**Heyford Park, Camp Road, Upper Heyford,  
Bicester, OX25 5HD**

**23/01959/NMA**

**Proposal:** Non-material amendment to 16/02446/F - amended elevation plans for 7 plots (plots 630-632, 634-635 & 646-647)

SECOND FLOOR PLAN

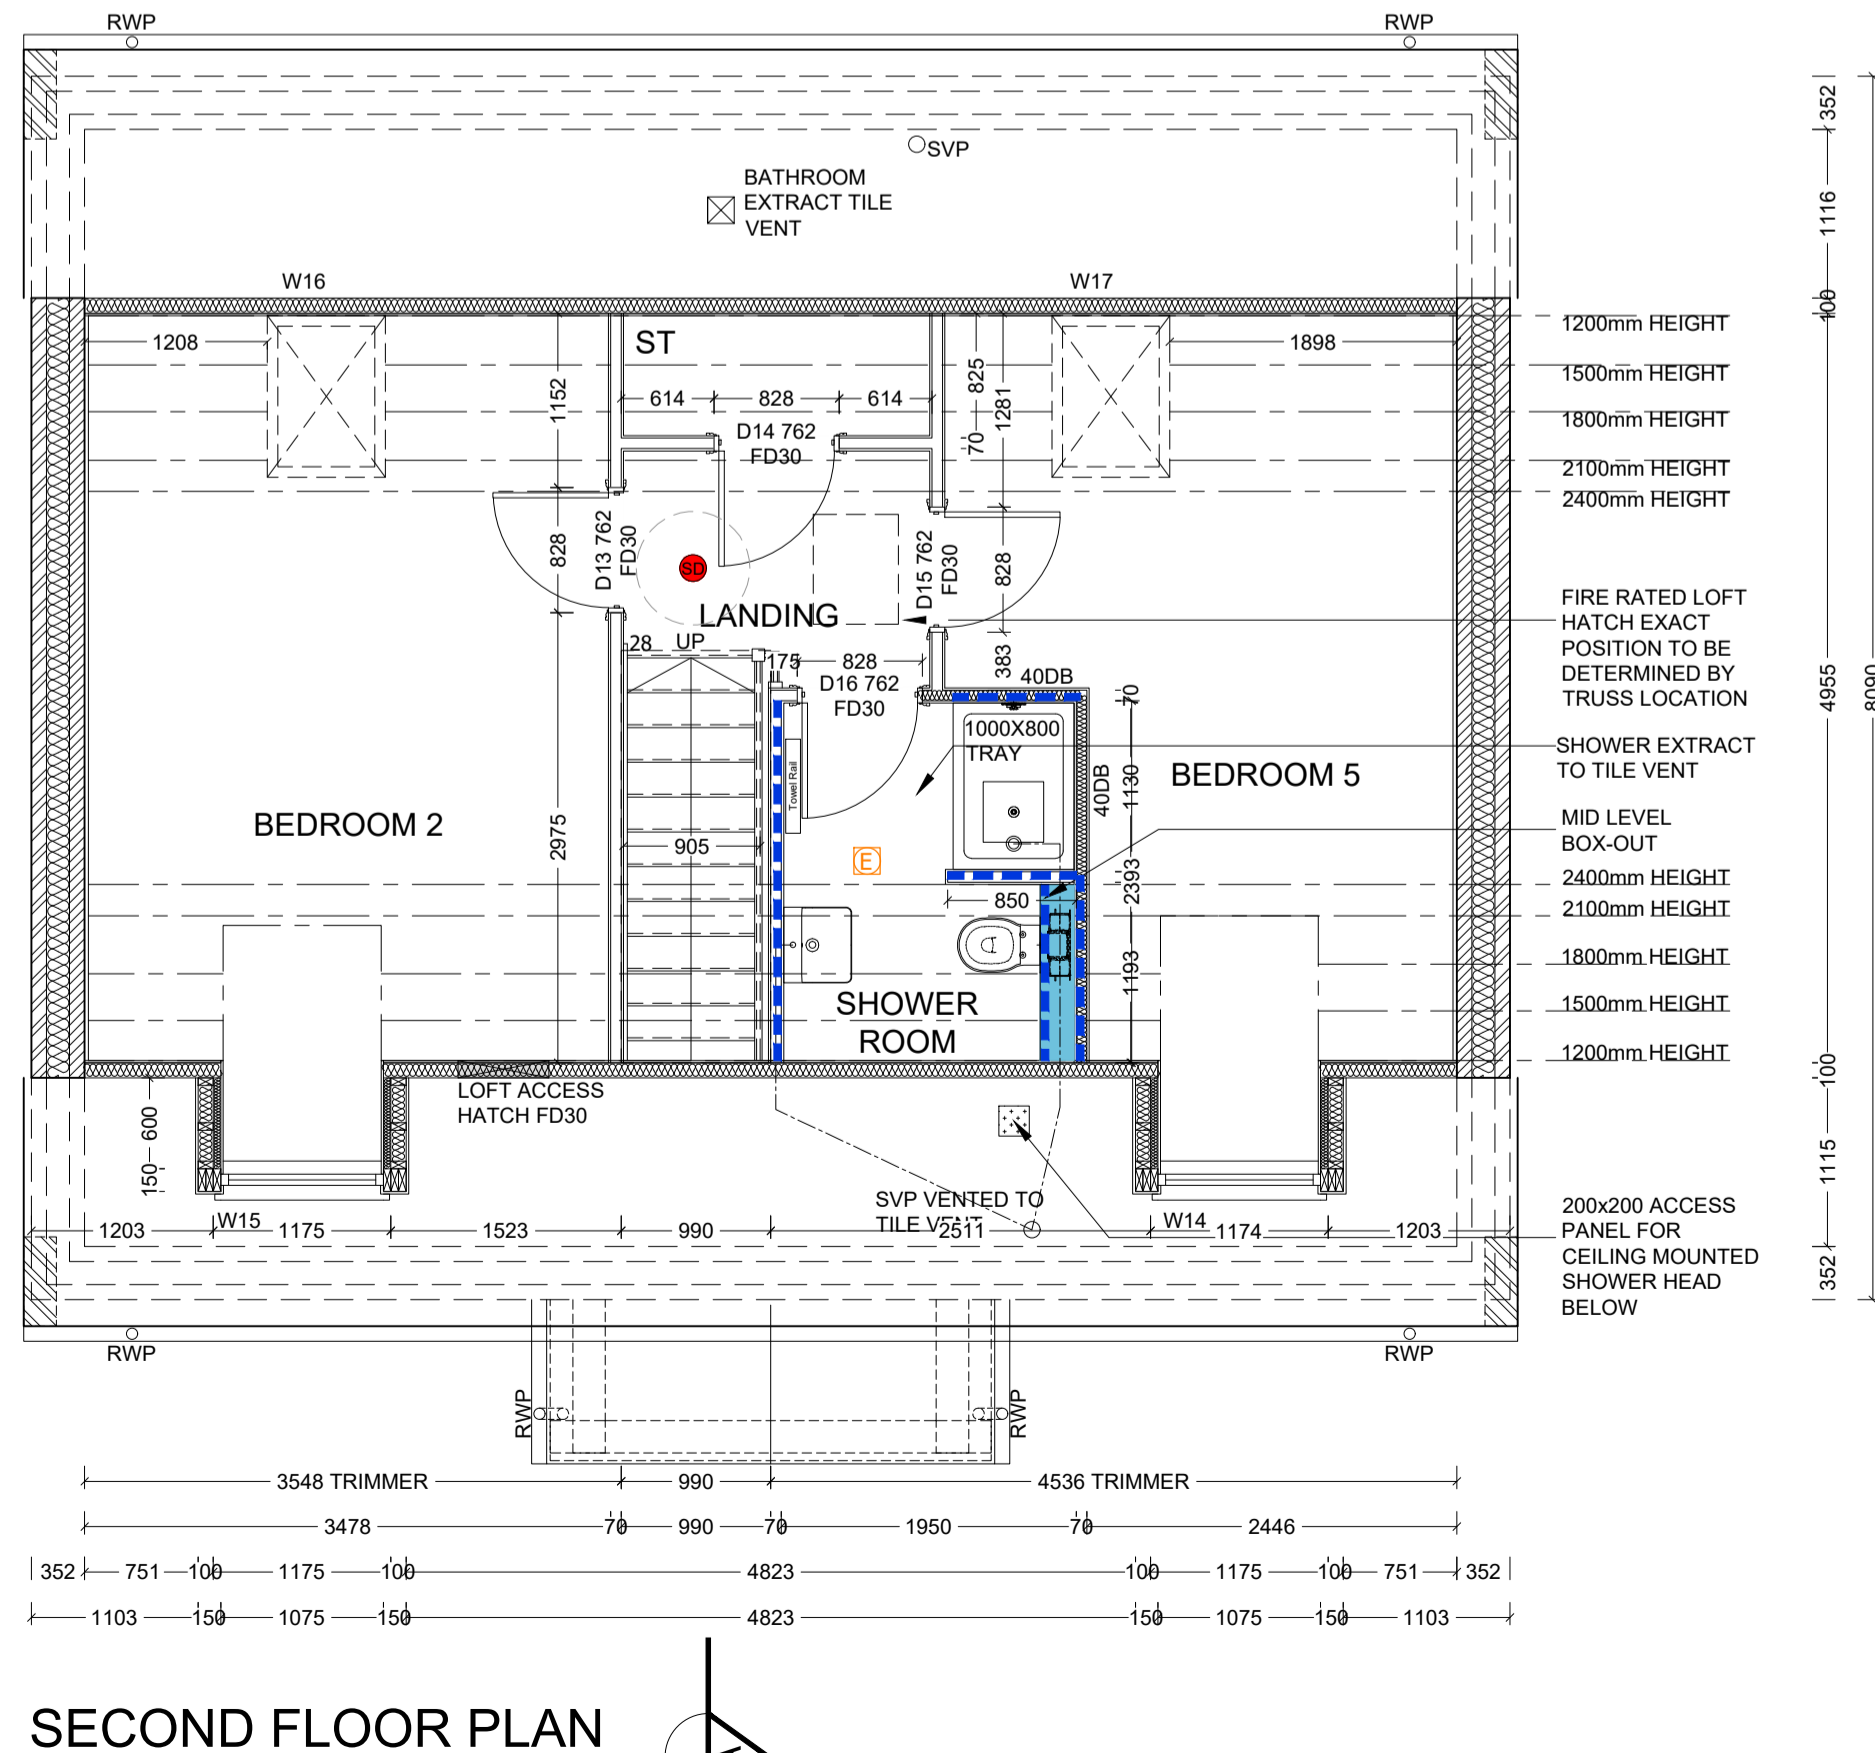
#### House Type 3D – Plot nos.630 and 631

- Brick built extruded porch added to front entrance;
- Elevational openings amended to better the symmetry of the façade;
- Living room window (W4) reduced by one pane to allow centralisation of porch and balancing of façade;
- 2nd floor shower room svp vented to roof to avoid need for destructive access.

Drawing Title:
**HOUSE TYPE 4A
ELEVATIONS [RENDER]**

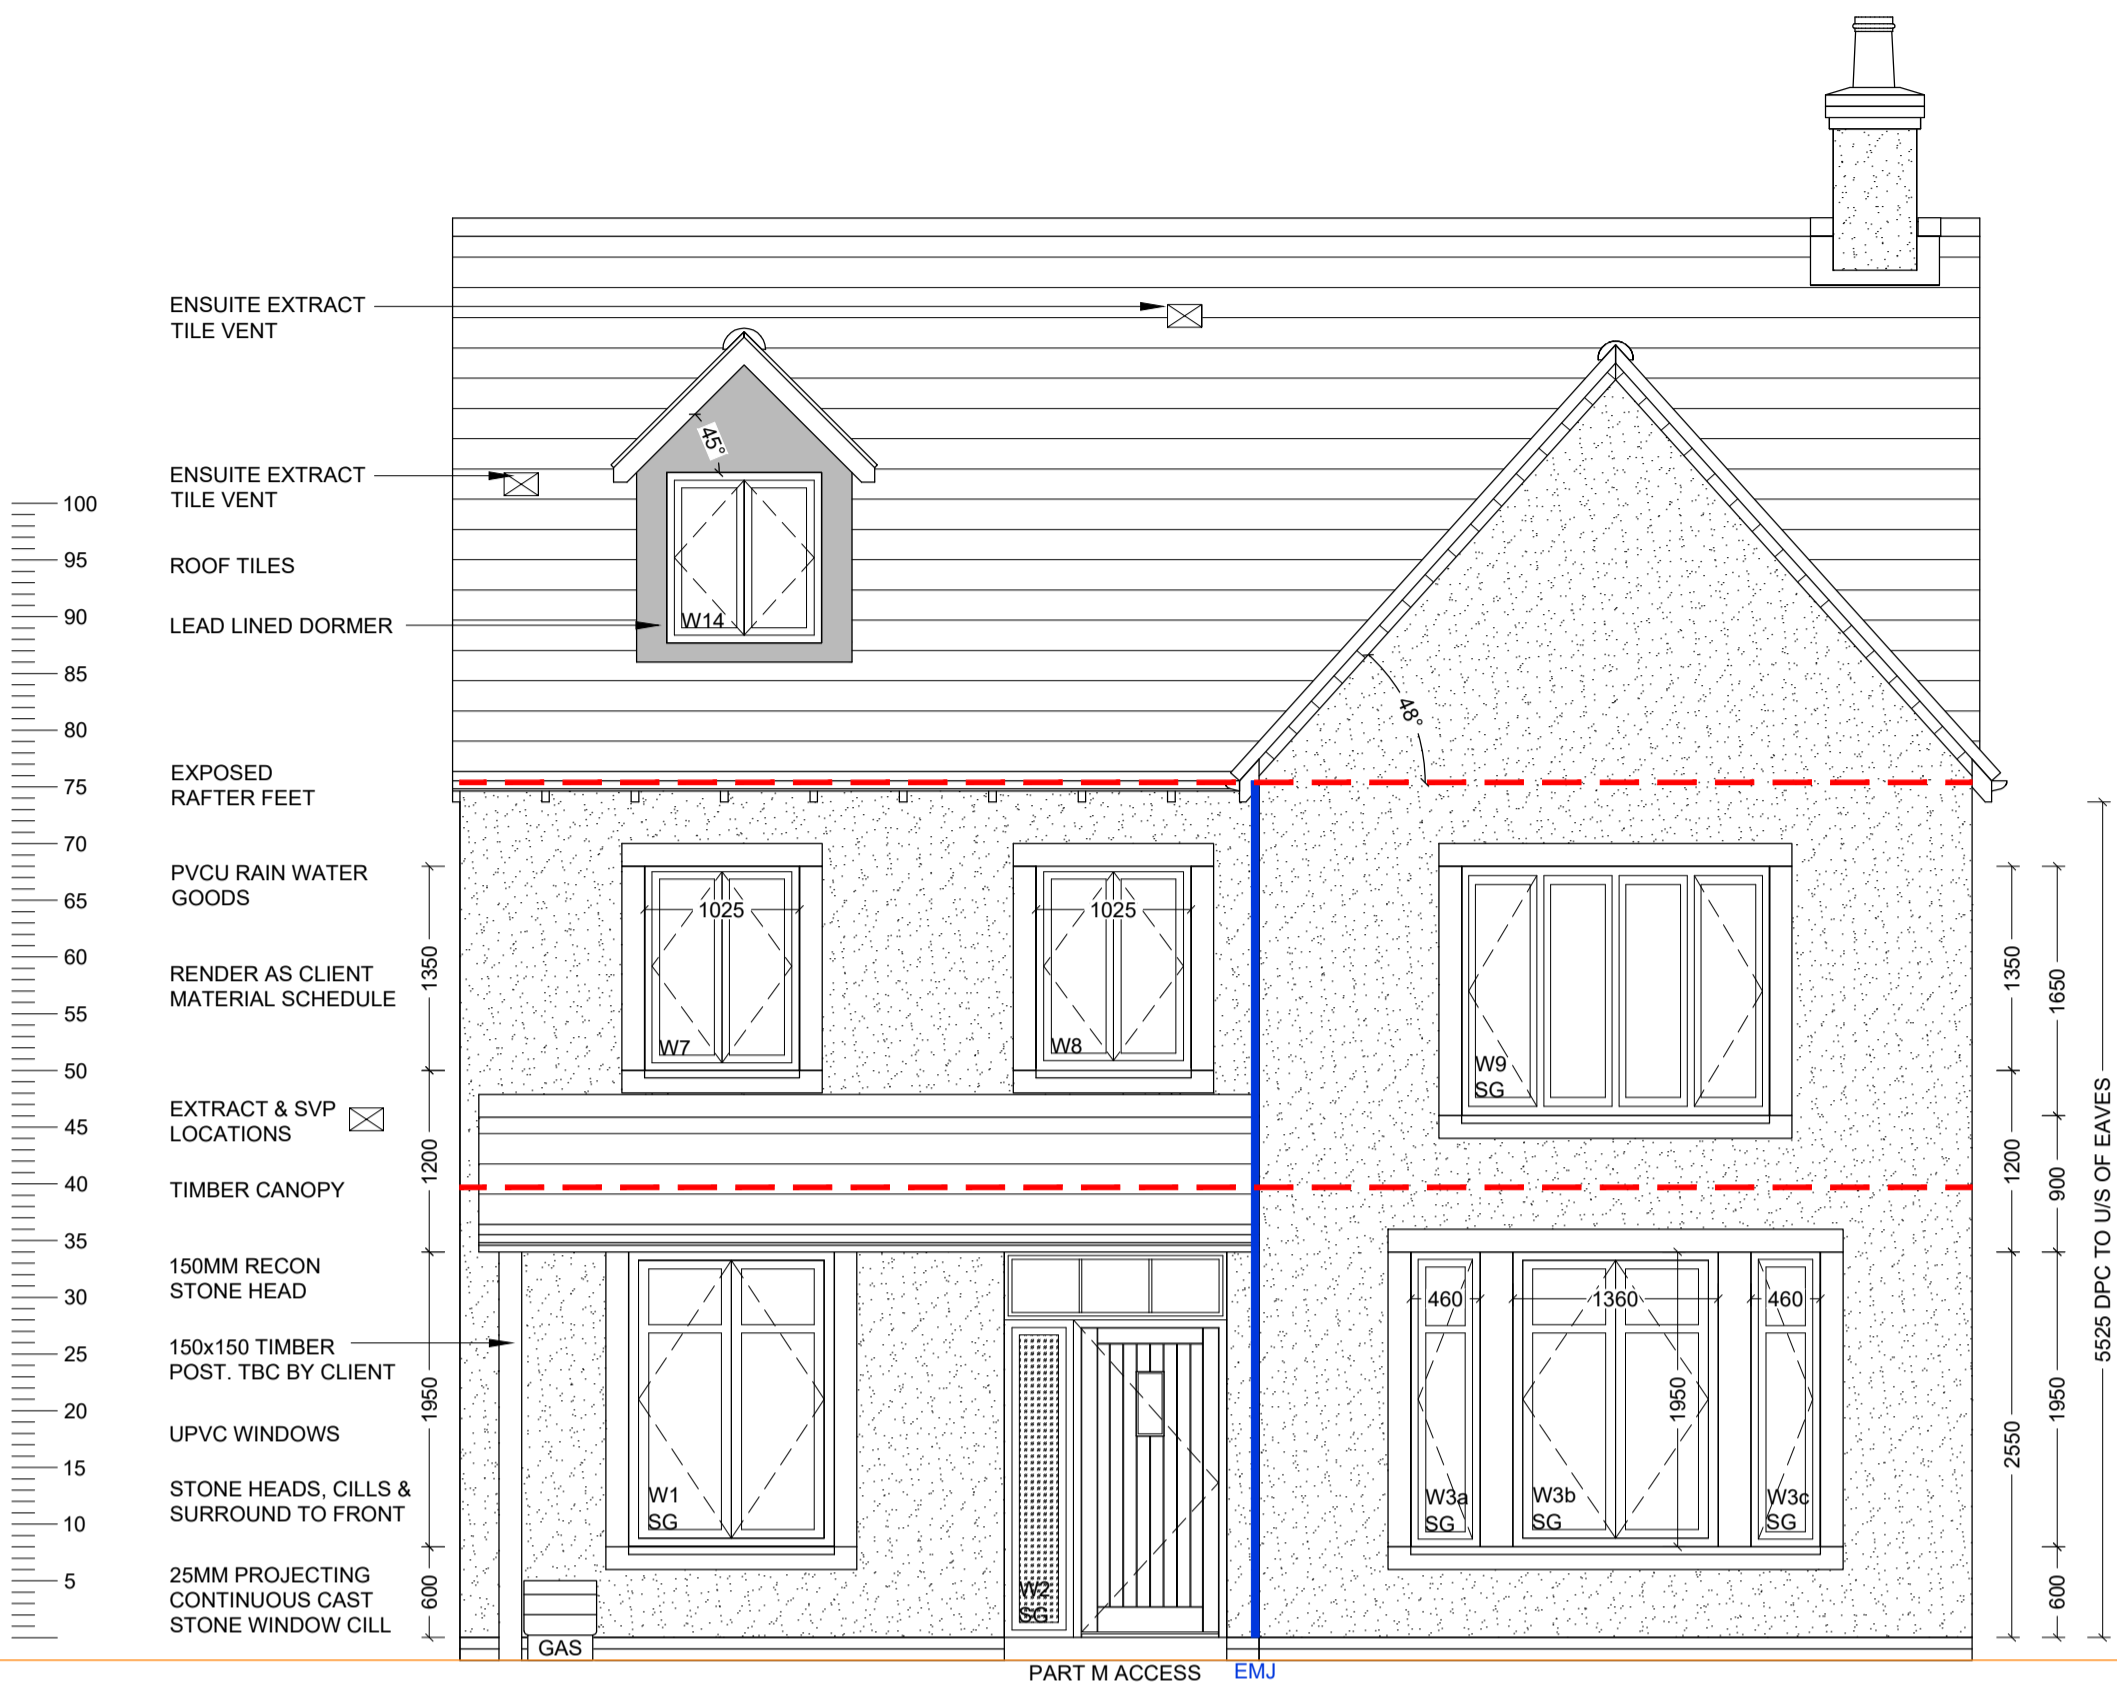
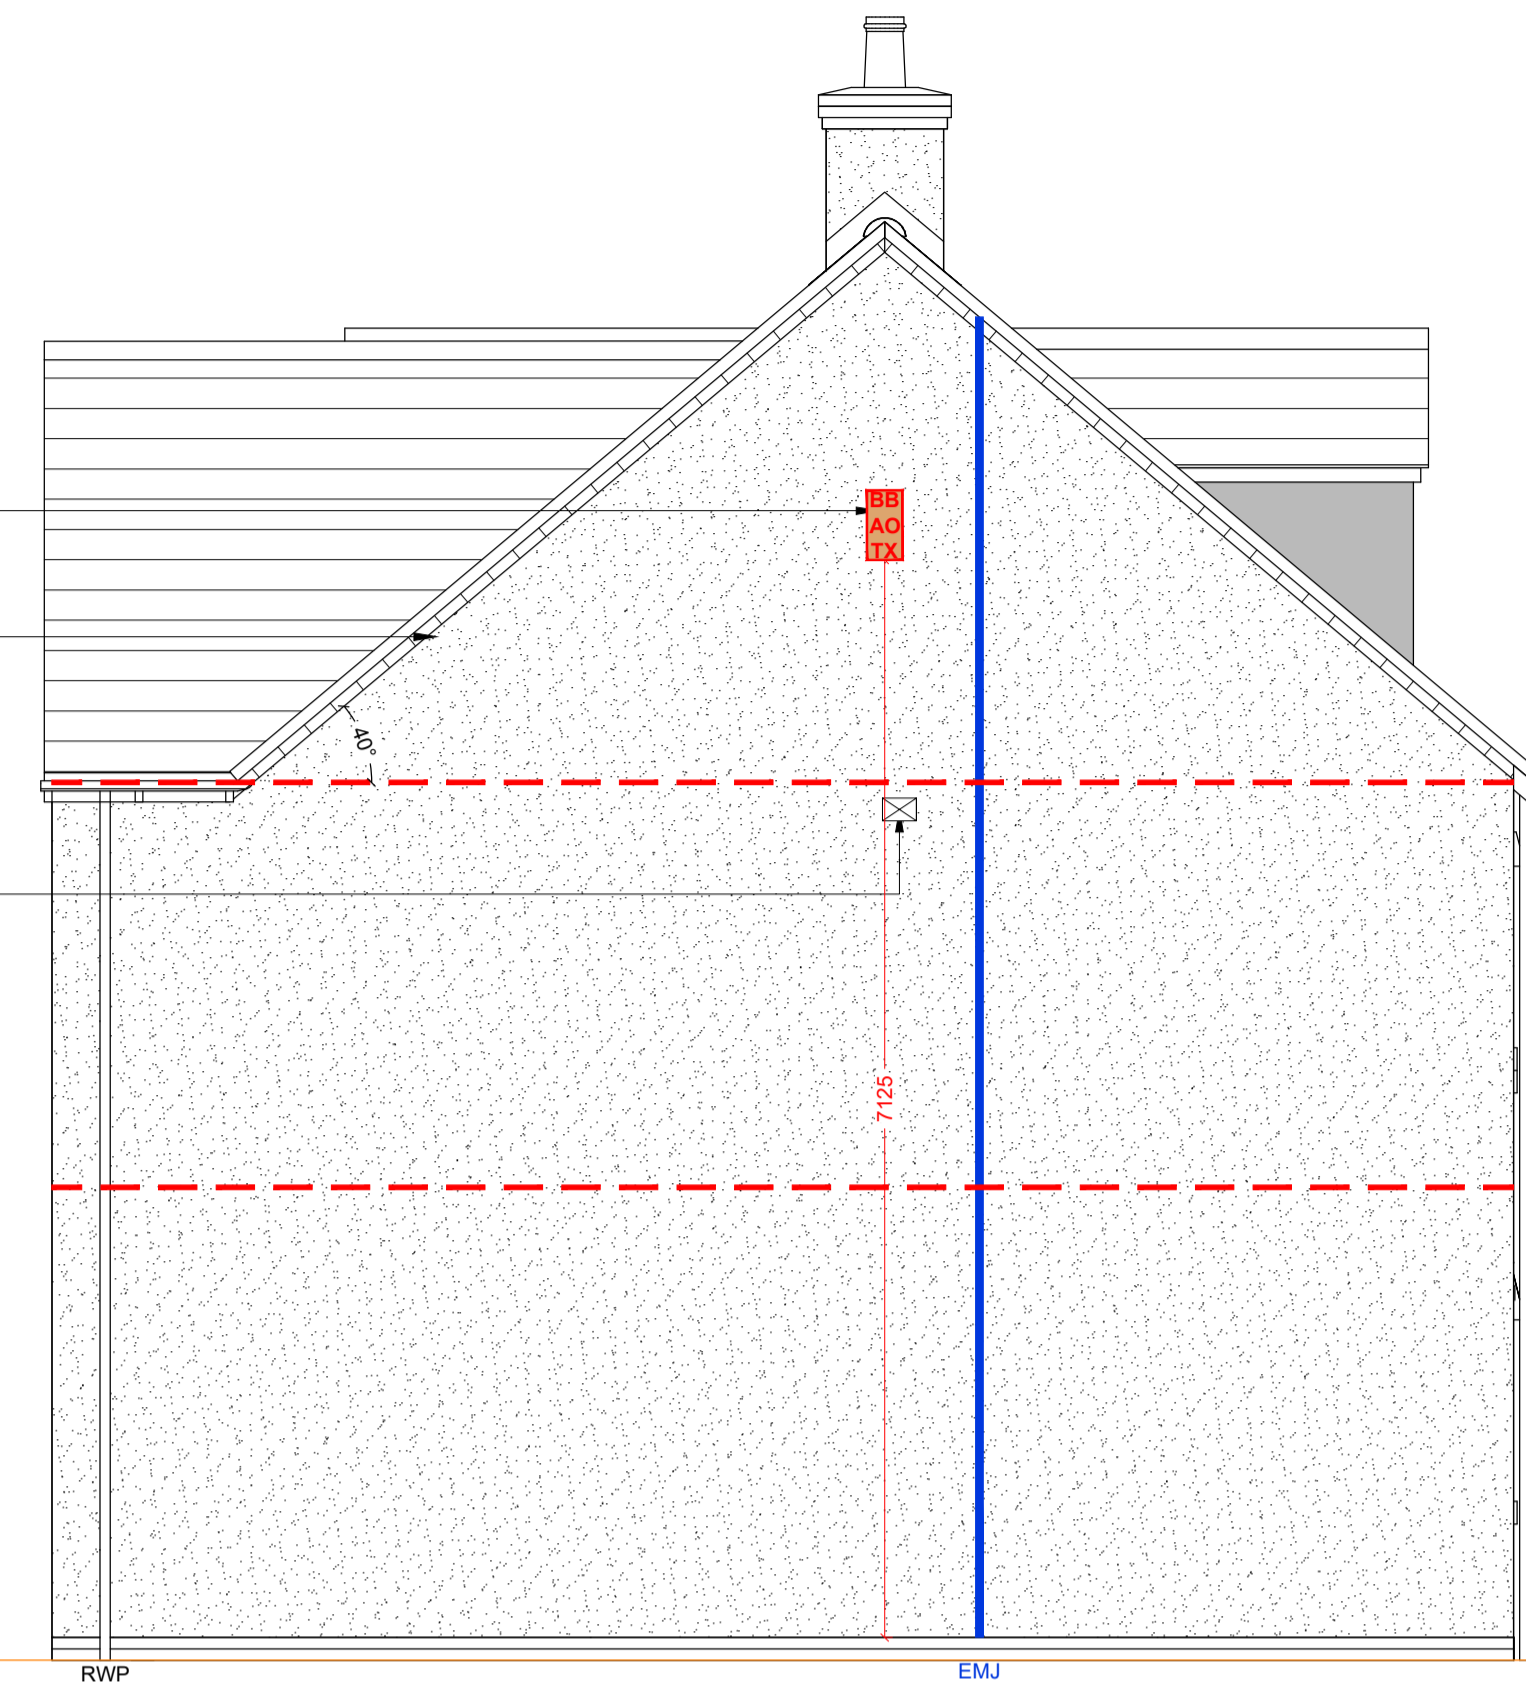
#### House Type 4A – Plot no.632

- Both render and brick elevations have stone surrounds added;
- Brick elevations have quoin detail added to front elevation corners;
- Render elevations have additional brick detailing to gable ends;
- 1st floor windows elongated.
